RE: Harbor View Block – Construction Overview

August 4, 1999

Enclosed are revisions to the Site Plan application for the Harborview Block in Portland, Maine. These revisions reflect changes in the design of the building, coordination of the site plan with the proposed Boothby Square design effort and response to the initial review comments forwarded by your office.

To: Orcutt Associates, Architects and Planners
From: Alan Holt, AIA; urban designer
Date: July 29, 1999
RE: Harborview Block proposal - 145 Commercial Street

COMMERCIAL STREET ELEVATION

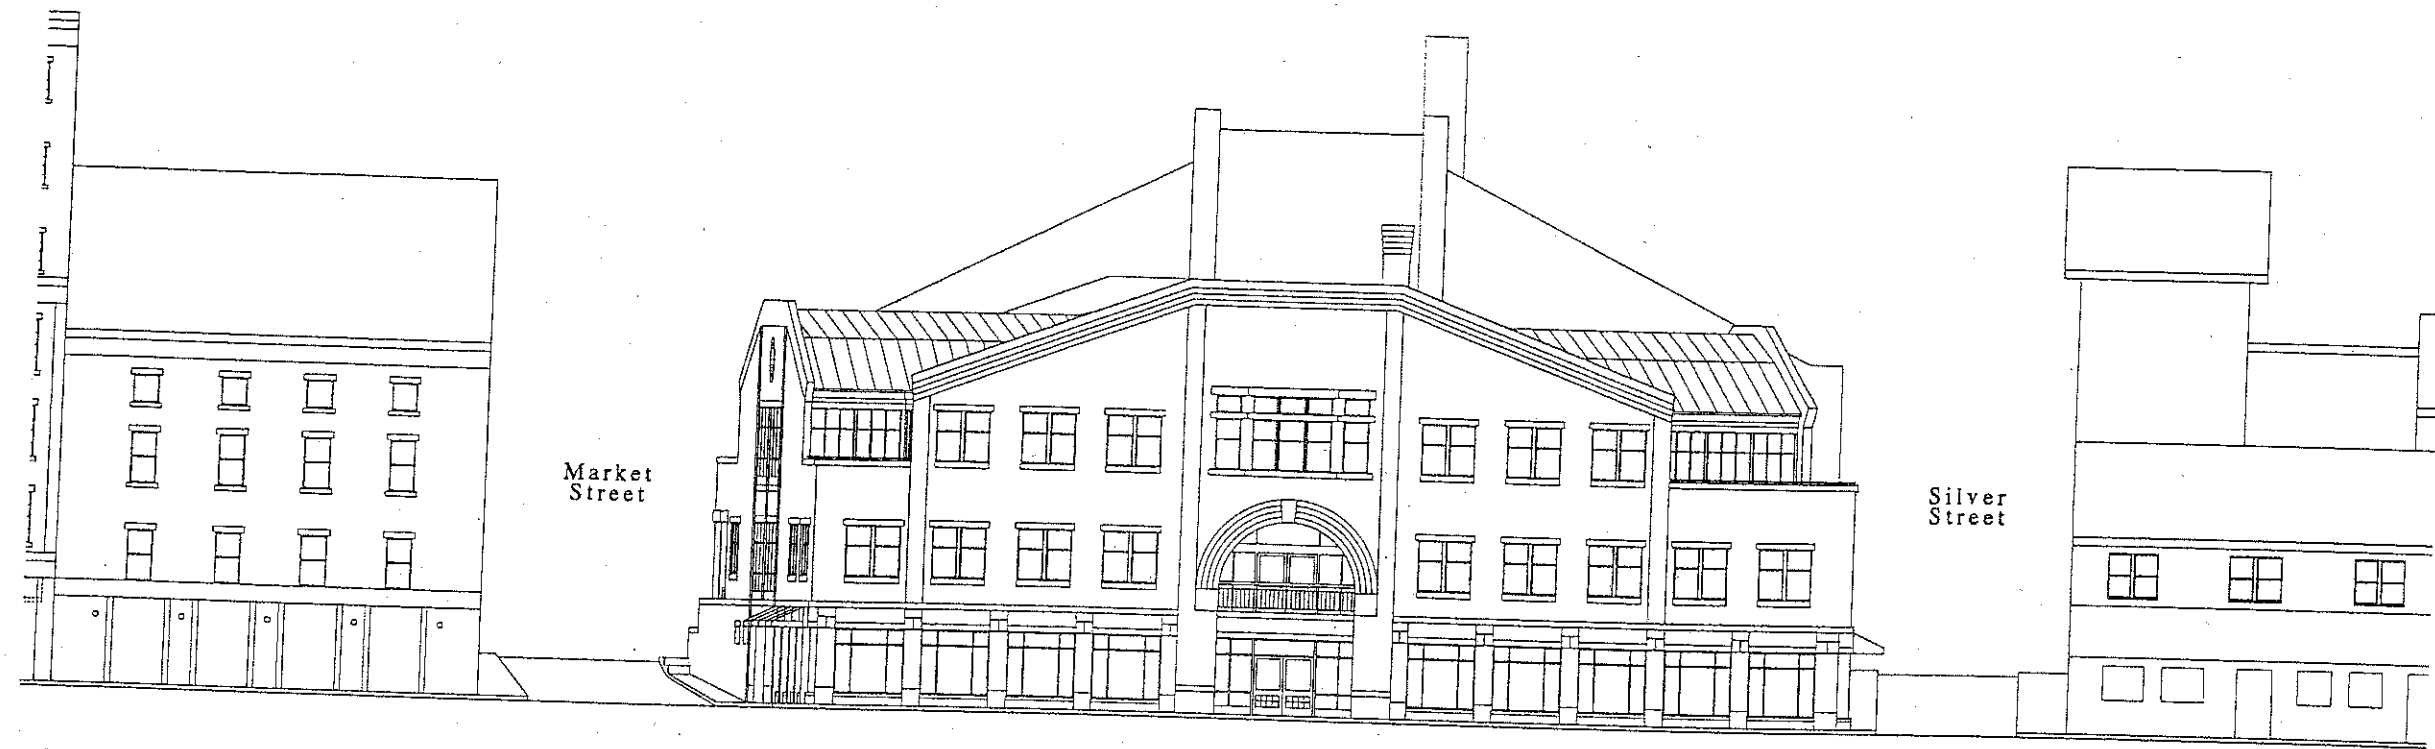
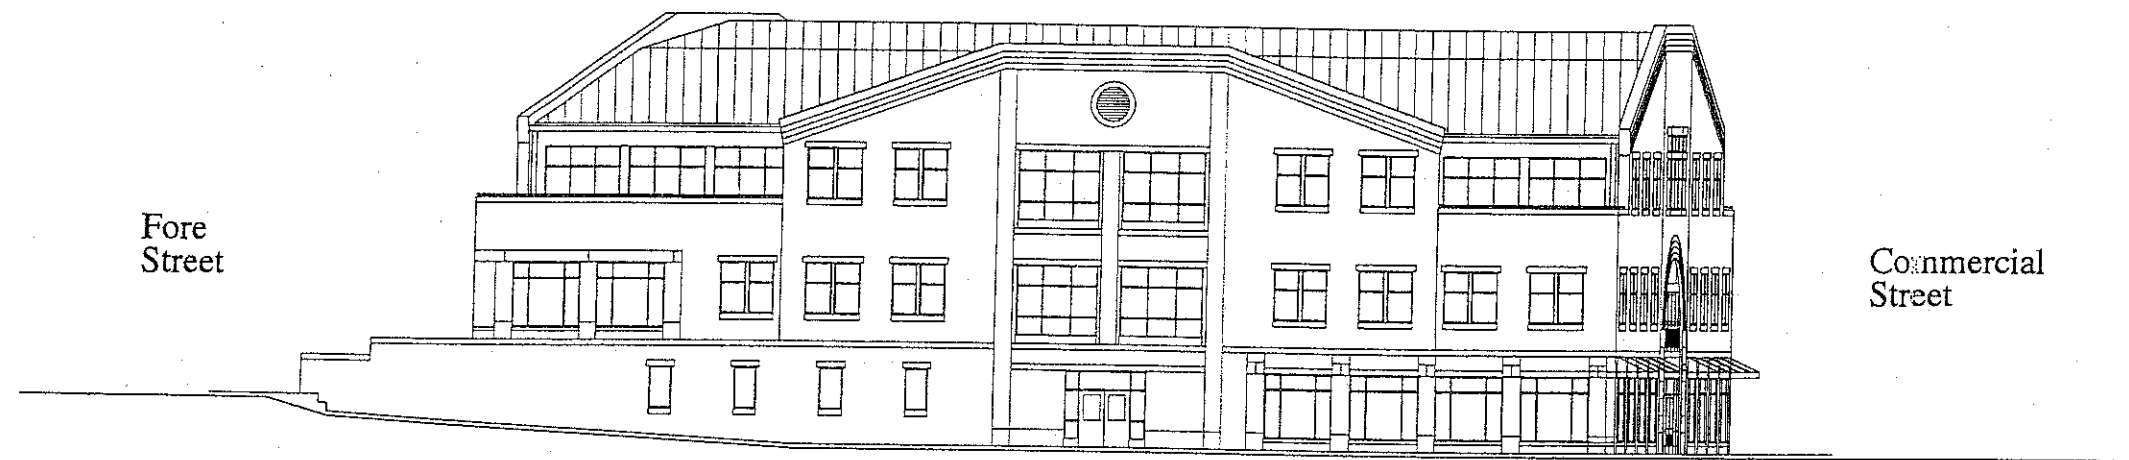
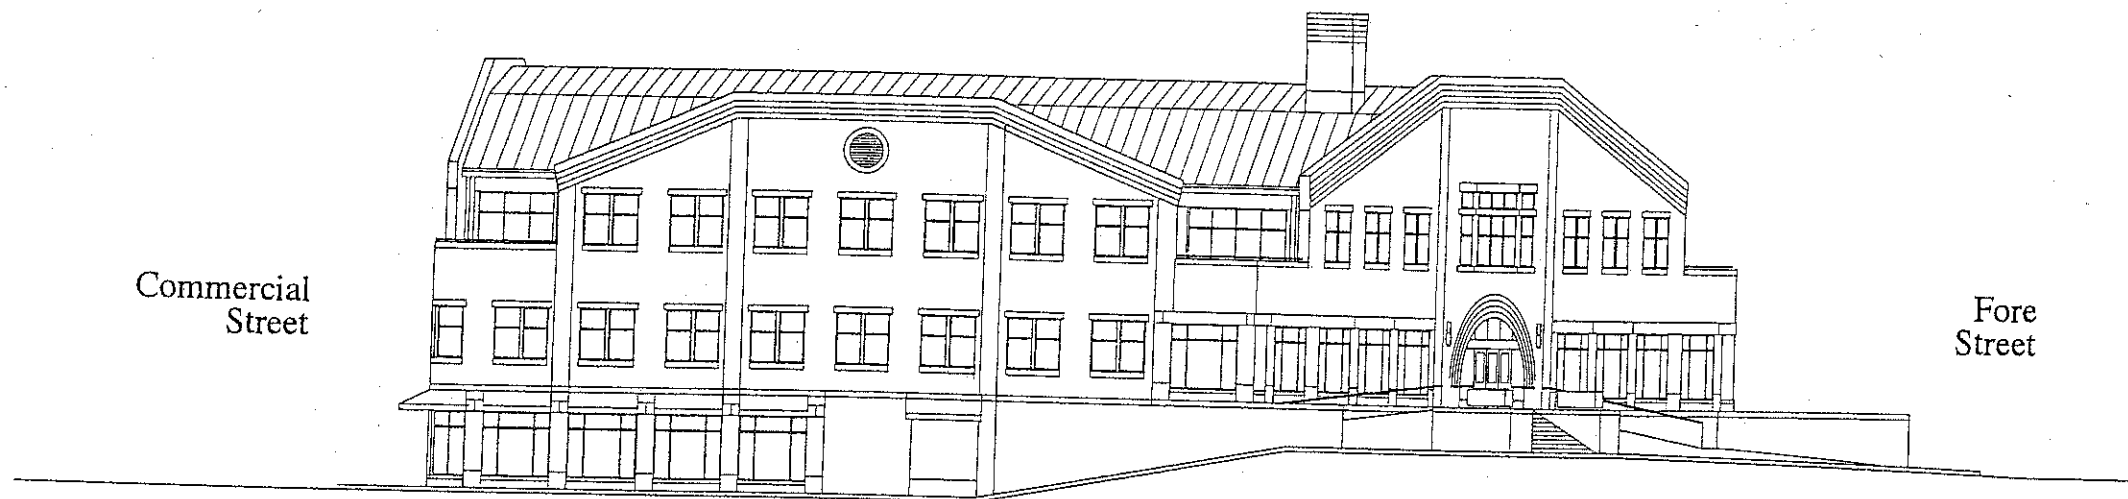
- c. (Elevation drawings) You have indicated that the submitted elevation drawings for Fore Street and Commercial Street are under redevelopment. Therefore, I am withholding comments until I see the current proposal. It is important that you submit elevations of all four street facades for a complete review.

- 1.a. A location for future public art has been identified on the Site Plan. A piece of public art is not part of this submission.
- 1.b. All street furnishings will be coordinated with final City choices for street furnishings in this area.
- 1.c. All four revised building elevations are part of this submission.
- 1.d. Buildings on adjacent parcels have been added to Site Plan.
- 1.e. Existing fire hydrants are located on the Site Plan.
- 2.a. The building height has changed substantially as a third floor has been added to the structure. See Item a above.
- 3.a. Final engineering drawings for this development have not yet been submitted. These items will be addressed in the final engineering drawings.

Site Plan  
Date: Aug. 19, 1999

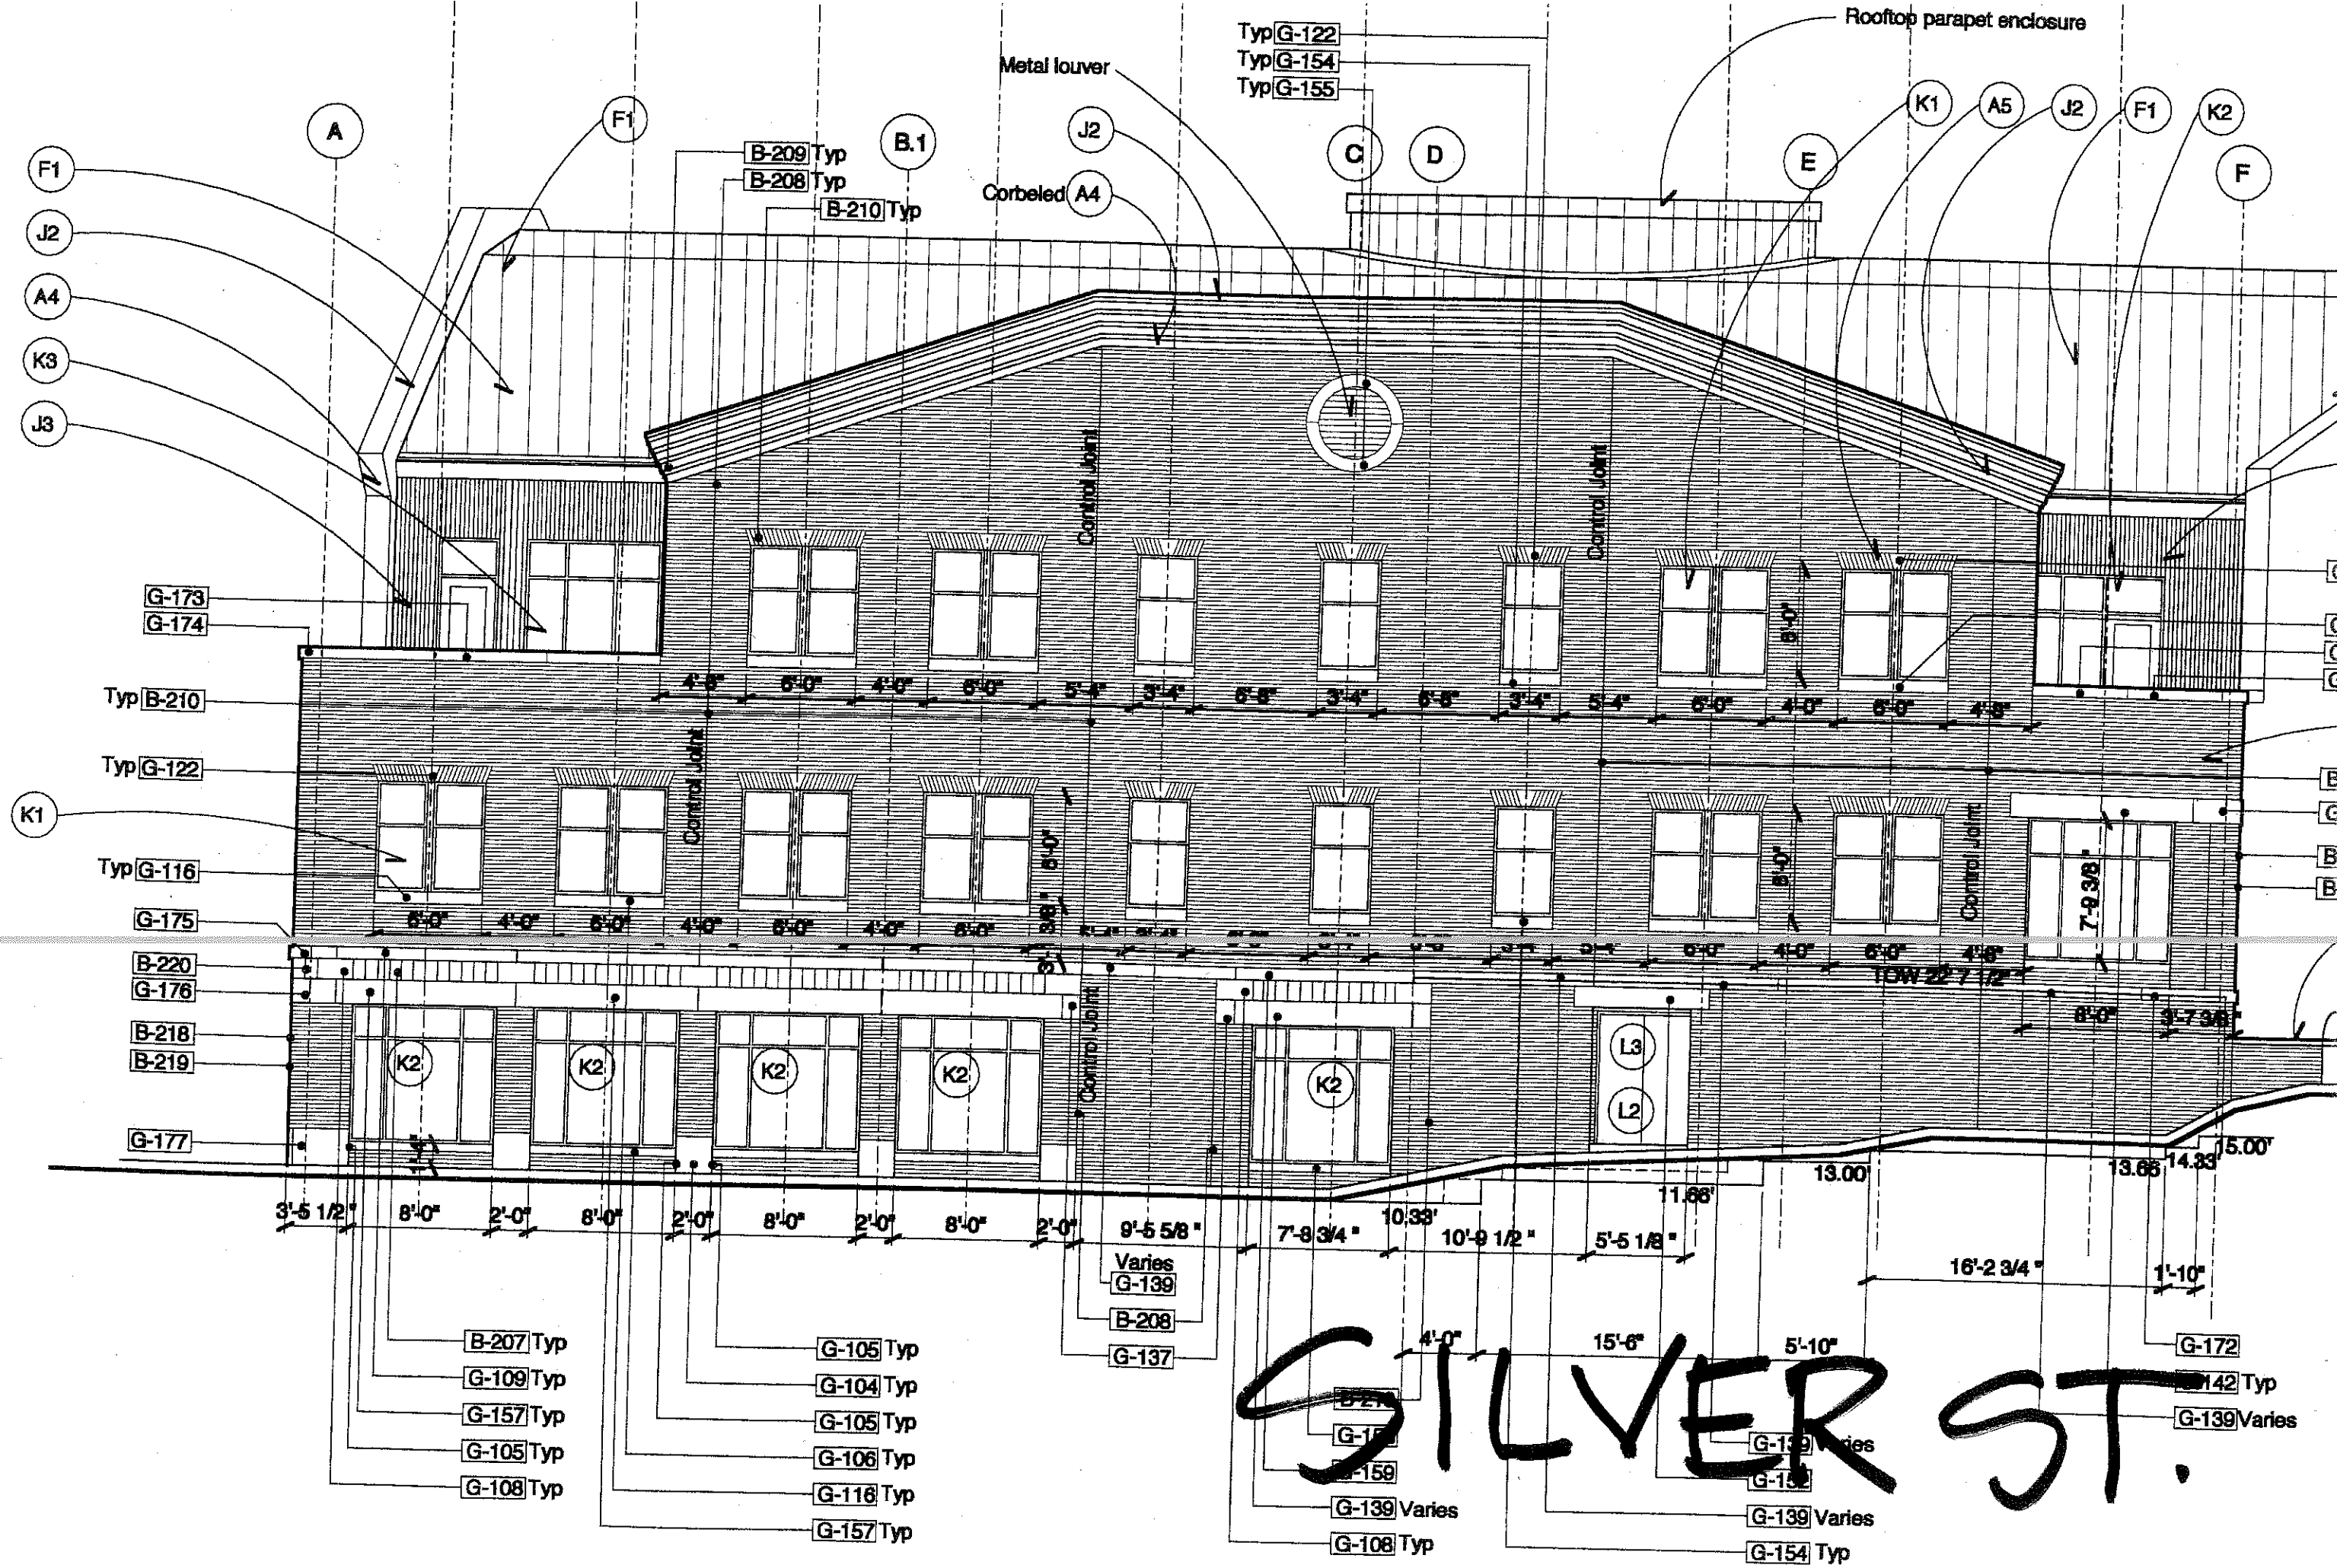
- 1. Random comments regarding submitted drawings.**
 - a. (on Site Plan) "Public art mounted on granite wall." Applicant should note that all public art is to be reviewed by the Portland Public Art Committee. This review would not have to be accomplished before the Planning Board hearing, however.

- b. (on Site Plan) On the various notes regarding installation of streetlights, streetscape amenities (trash receptacles, bicycles racks, etc.): The applicant should coordinate final choices to match the City's plans for the area. The applicant should note that the City is undertaking a review of streetlights in the Old Port this year. Likewise, street plantings, planters, etc. should be coordinated with the City's plans for reconstruction of the ~~Boothby Square Plaza.~~

- d. Please indicate the approximate location of buildings or structures on adjacent parcels.
 - e. Please indicate locations of fire hydrants, existing and proposed, on the Site Plan.

The proposed Boothby Square design plan calls for retaining the historic granite steps at the corner of Fore and Market Streets. These steps have been added to the Site Plan.

One of the existing trees (Summit Ash) on Commercial Street sits directly in front of the opening entrance to the building. This tree will be relocated in an adjacent planting spot and the entrance to the building will remain free of planting. If the Summit Ash does not survive transplanting, the applicant will replace the tree with a matching specimen.

The landscape area fronting the building facing Fore Street has been modified to include a surround of low granite curbing. This curbing will contain the landscape edge and provide a neat foreground to the building.
